# Planning Inspectorate

EN010158

15 December 2025

### Application by Rosefield Energyfarm Limited for an order granting development consent for the Rosefield Solar Farm

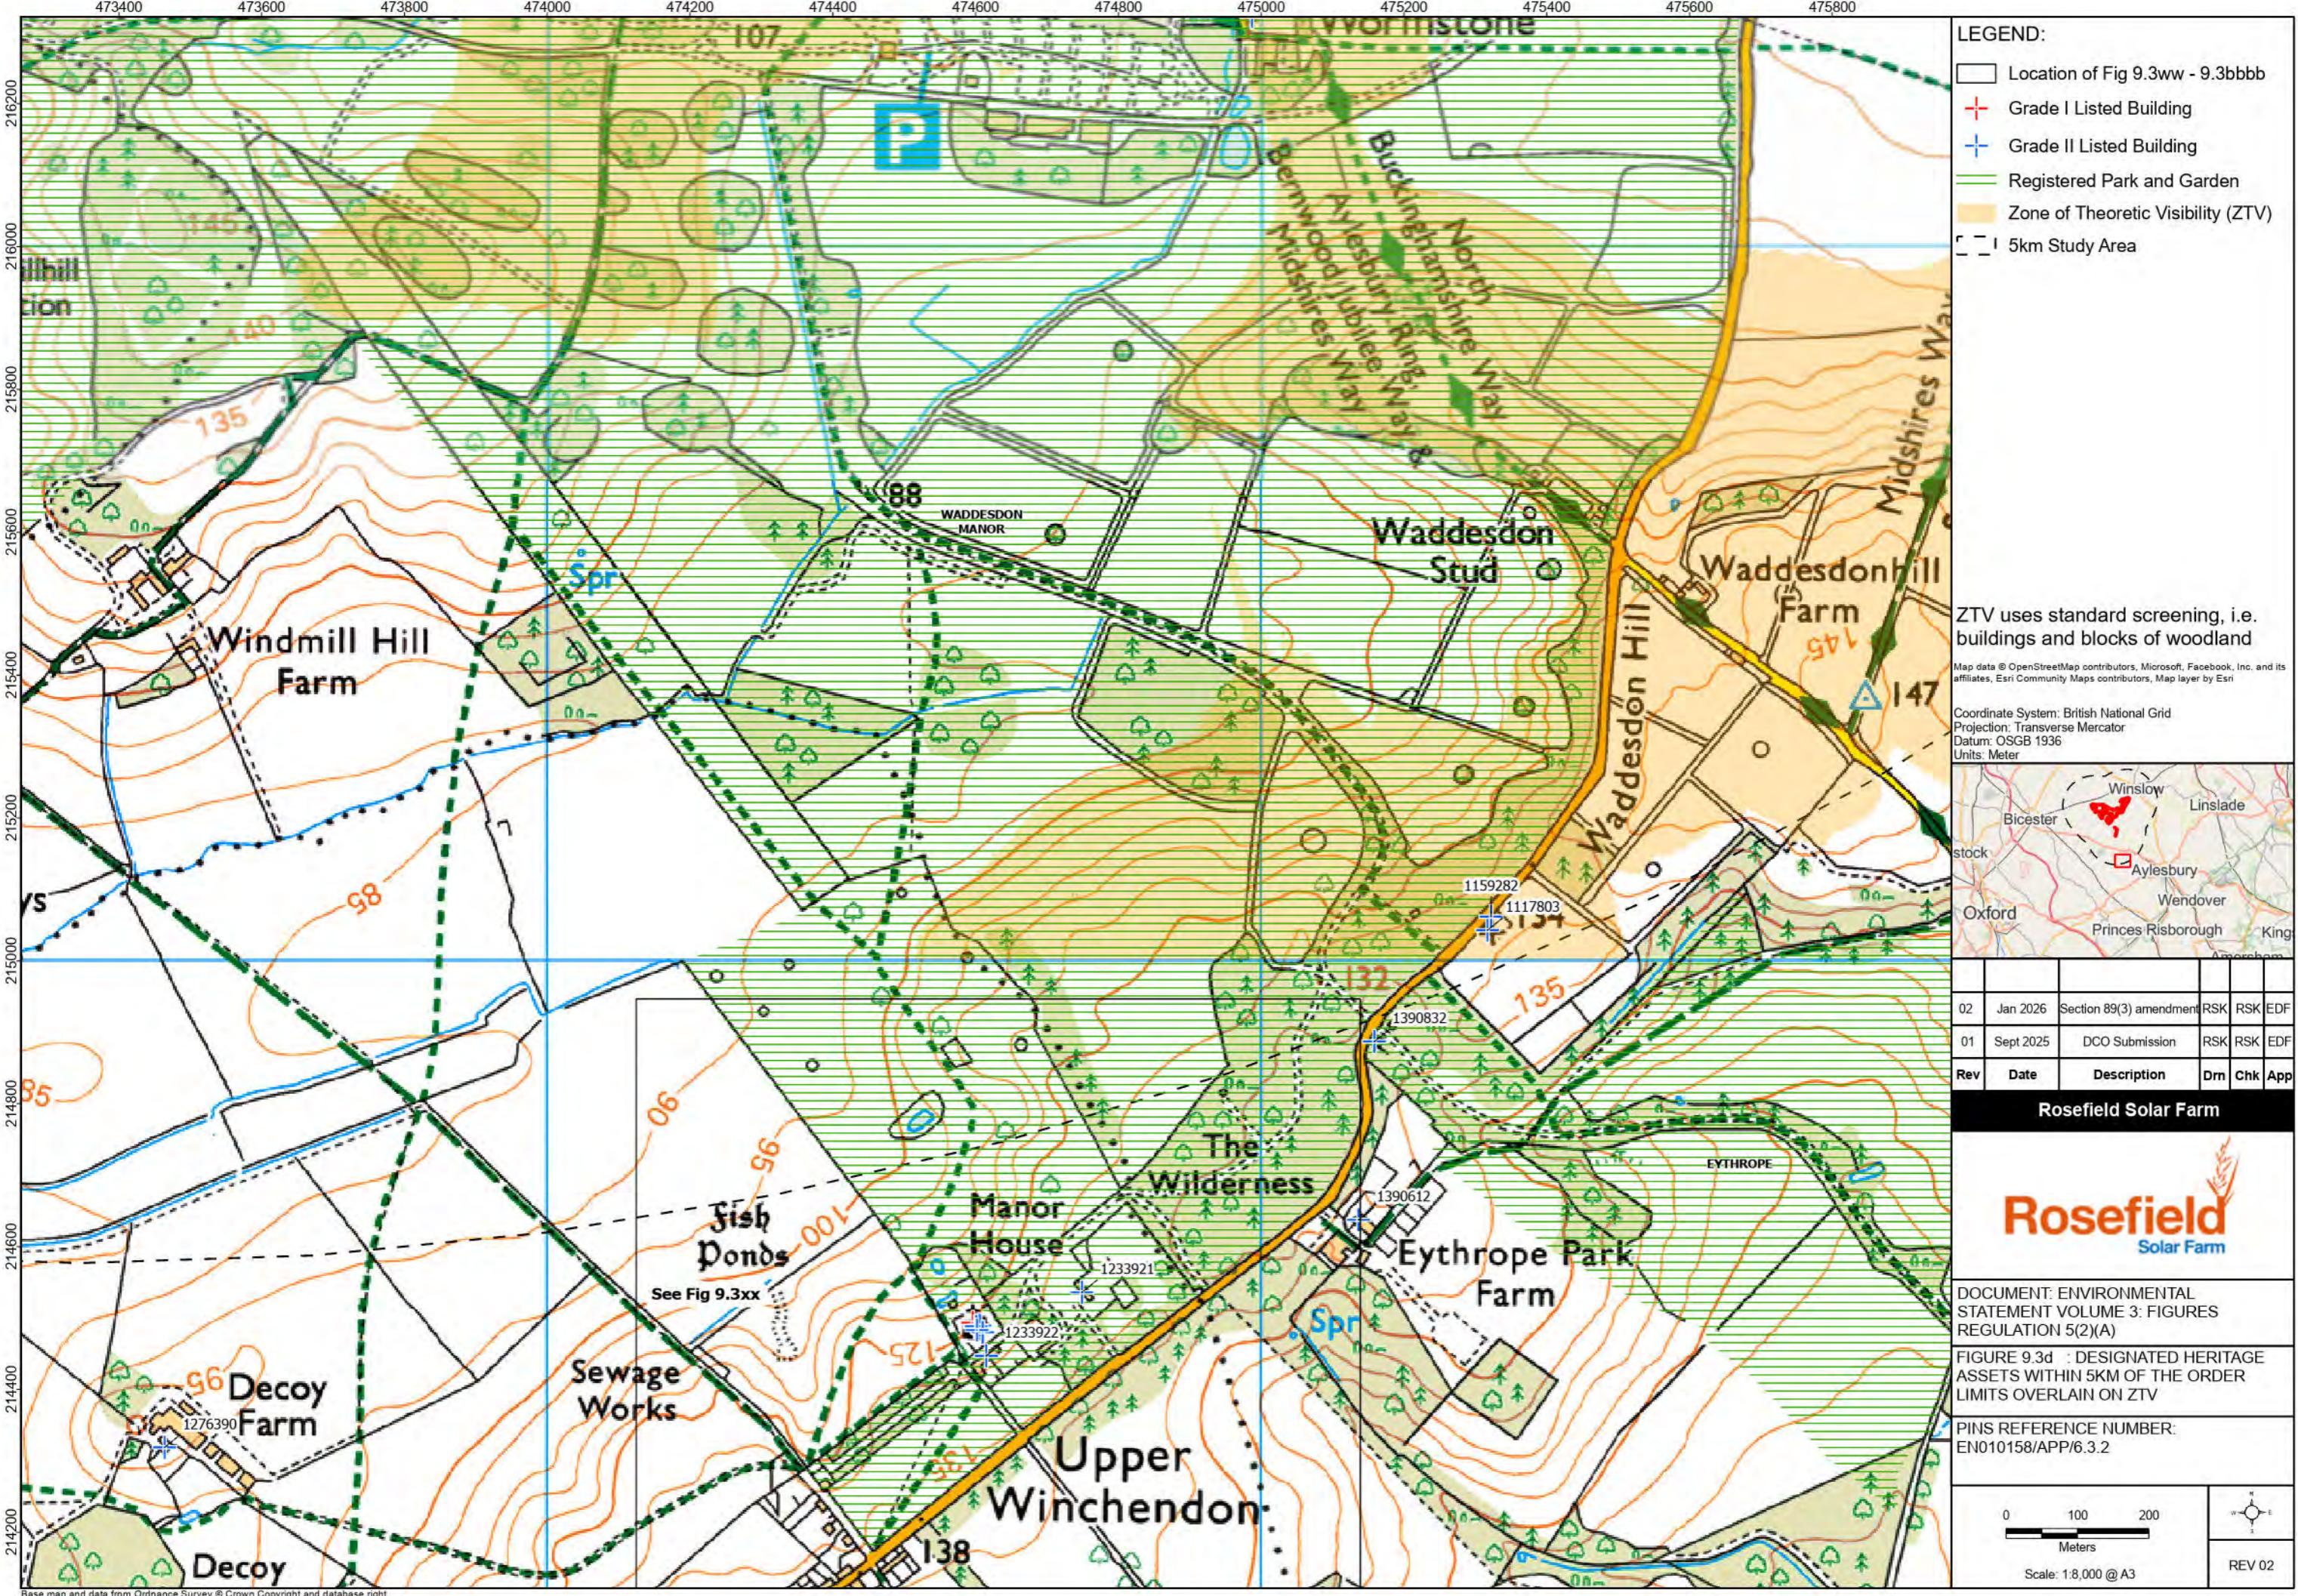
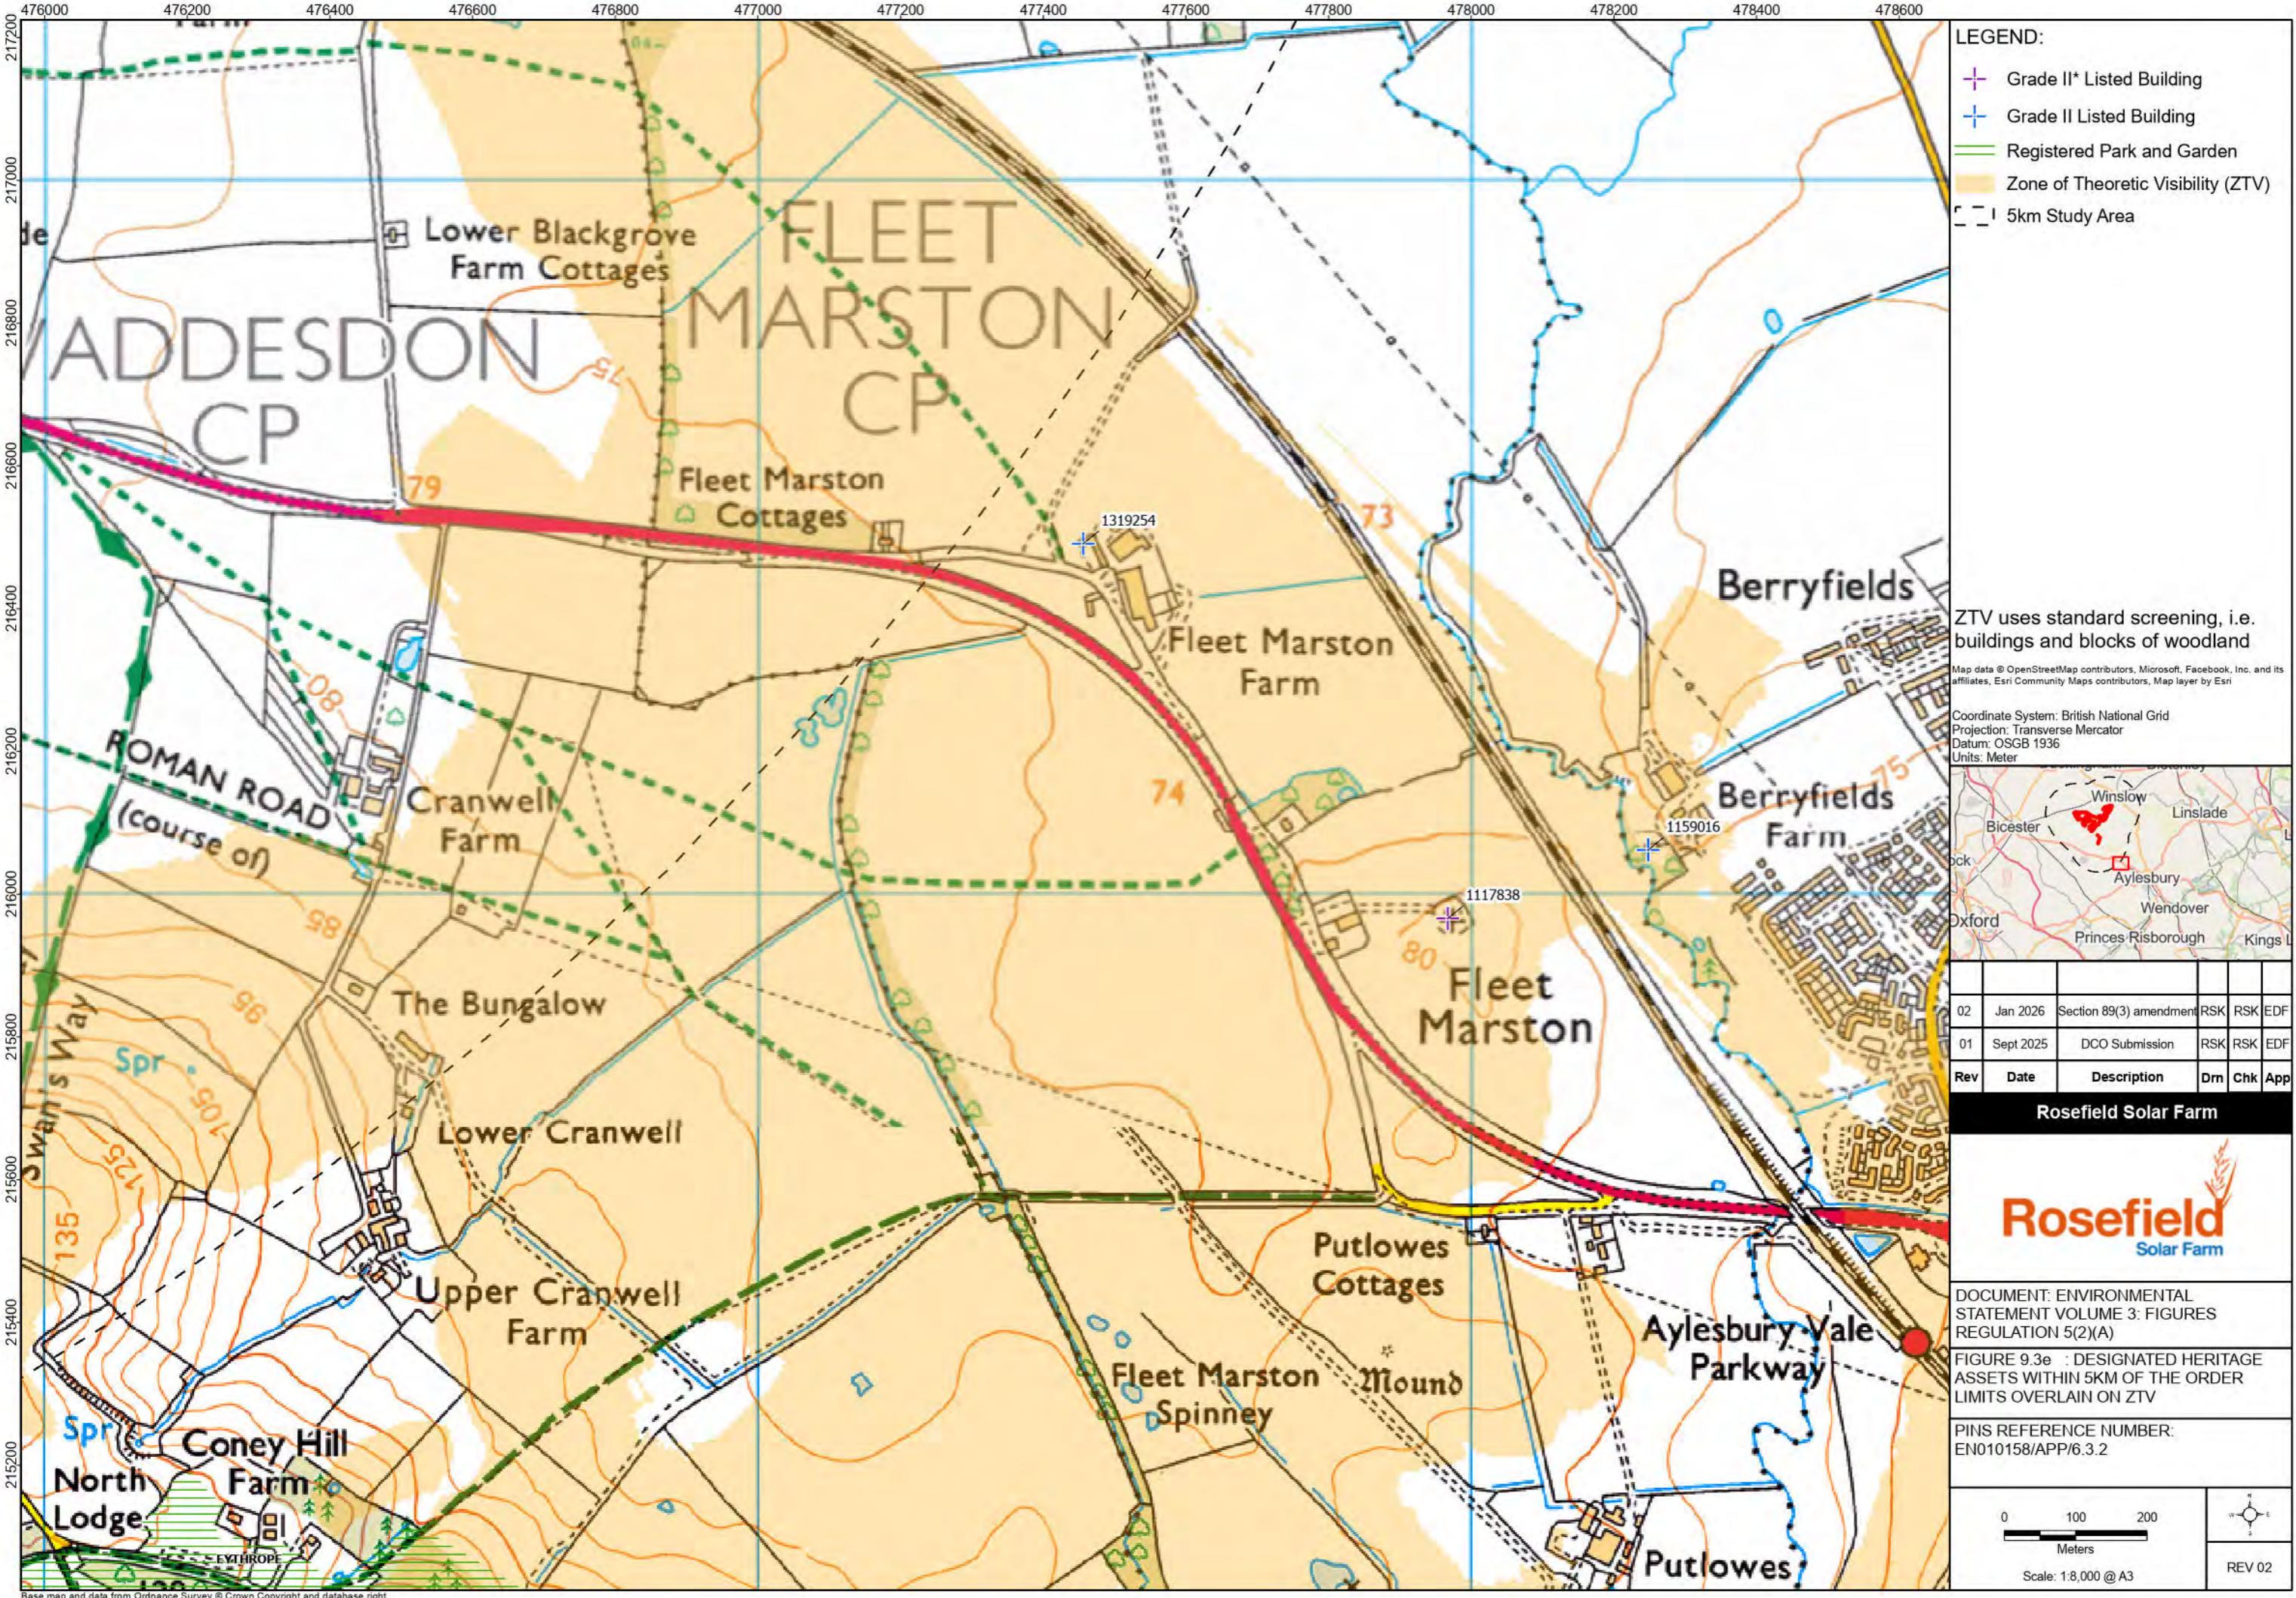
In addition, in ES Chapter 9: Cultural Heritage Figures [APP-068], the labelling of heritage assets is absent or unclear across the majority of cultural heritage figures. For example, the labelling of listed buildings within villages in figure 9.4 is unclear. Information provided in the legend for the figures is also sometimes incomplete. Review and update the figures to ensure that they are legible and can be easily cross-referenced with the assessment in ES Chapter 9: Cultural Heritage [APP-052].
